Department of Primary Industries

OUT14/27859

**Tinda Creek Sand Quarry Expansion (SSD 4978)
Response to exhibition of Environmental Assessment**

Tinda Creek Sand Quarry Expansion (SSD 4978) Response to exhibition of EIS Additional comments by NSW Office of Water

Figure 1 – Modelled Final Landform Domain 3 Extraction

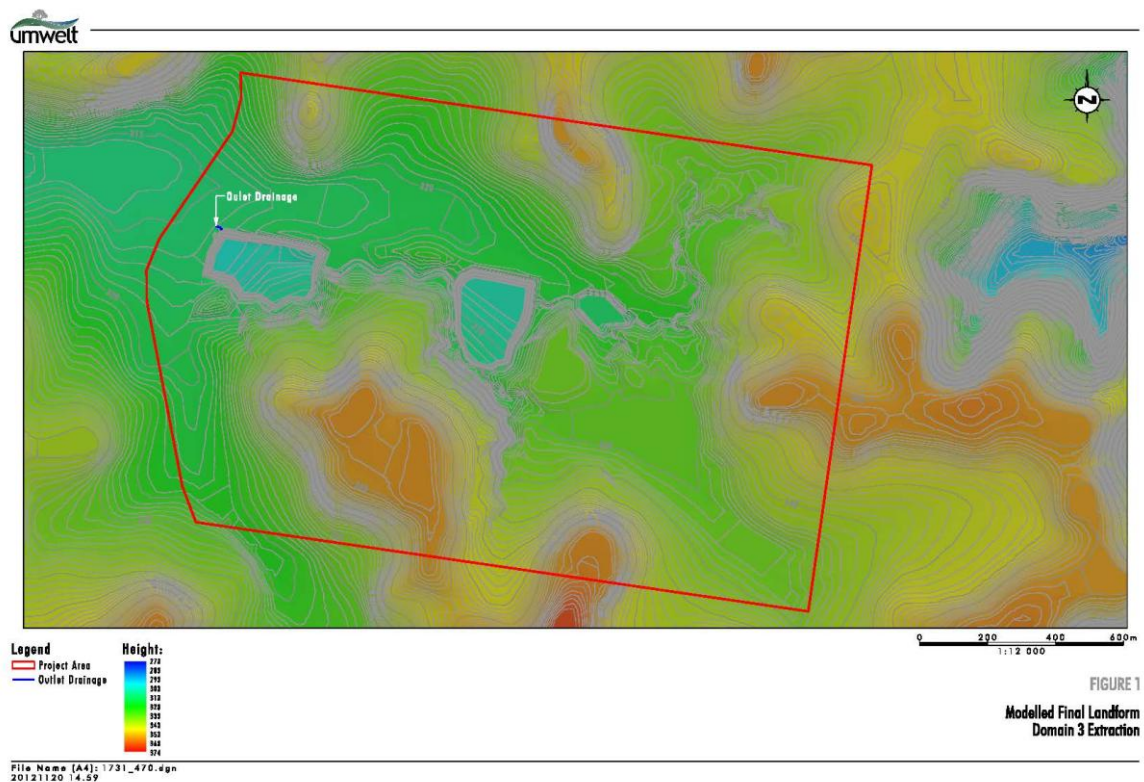
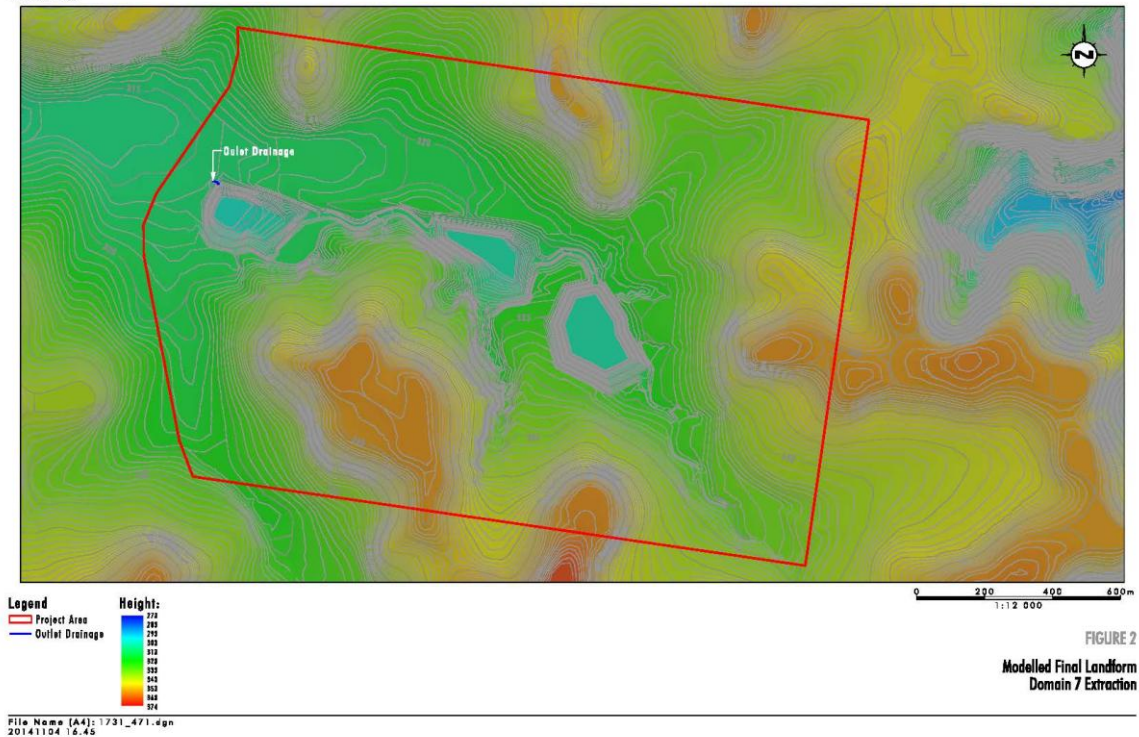
Figure 3.1 in the Groundwater Assessment report shows two northern tributaries of Tinda Creek flow from Yengo National Park into the site. The proposed expansion of extraction area 3 would remove these tributaries and Mellong Sandmass Swamp Woodland which occurs along a section of these watercourses. It is noted that the final alignment of Tinda Creek will follow the alignment of the Southern Diversion and then following the existing alignment of Tinda Creek (see Section 4.9.1, page 4.41 of the EIS) but it is unclear what is proposed in terms of the northern tributaries and whether it is proposed to rehabilitate these watercourses and the riparian corridors once the proposed quarrying is completed, or if the creeks are proposed to flow into the proposed north-eastern diversion as part of the final landform for the site (see Figure 4.3 a). Details need to be provided on this.

The proponent should be required to rehabilitate the watercourses on the site as natural systems which mimic the local area.

Figure 3 - Topography and Drainage

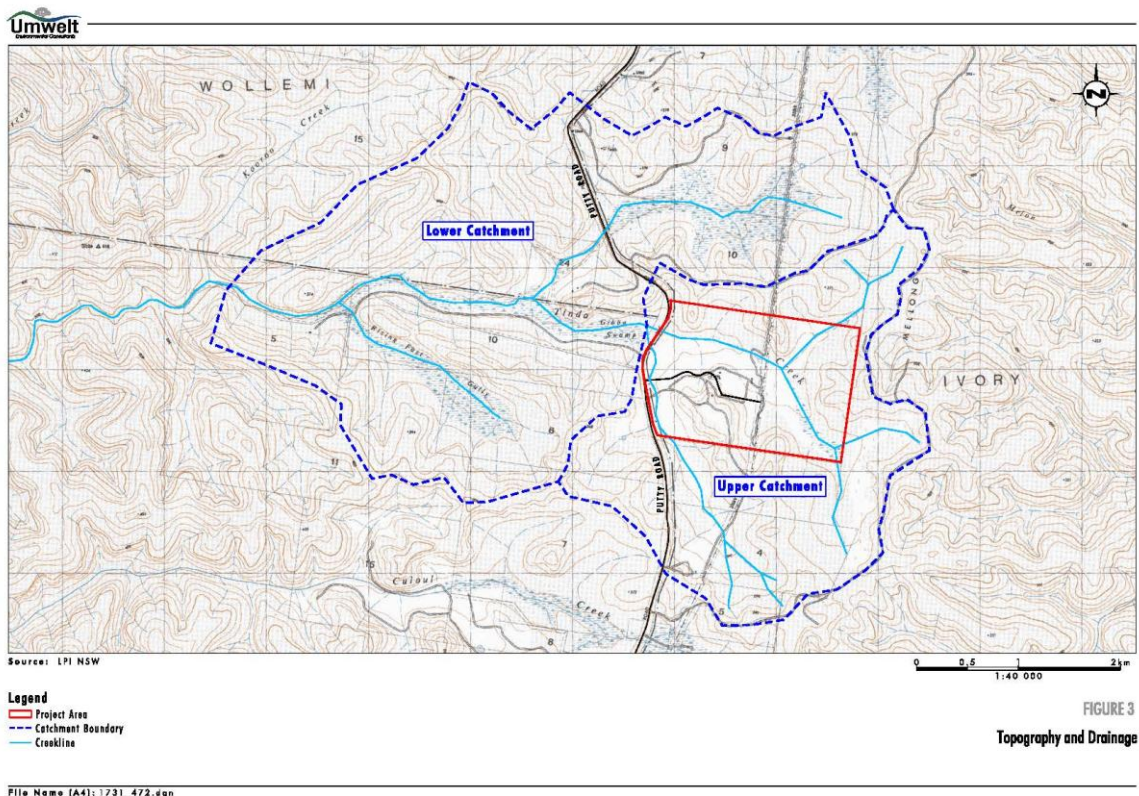
In any future water impacts modelling, the volume of downstream baseflow losses should be reassessed to confirmed baseflow reduction volumes. If proven to be significant, this will need to be accounted for and licensed as part of the surface water "take" applying to the quarrying activities.
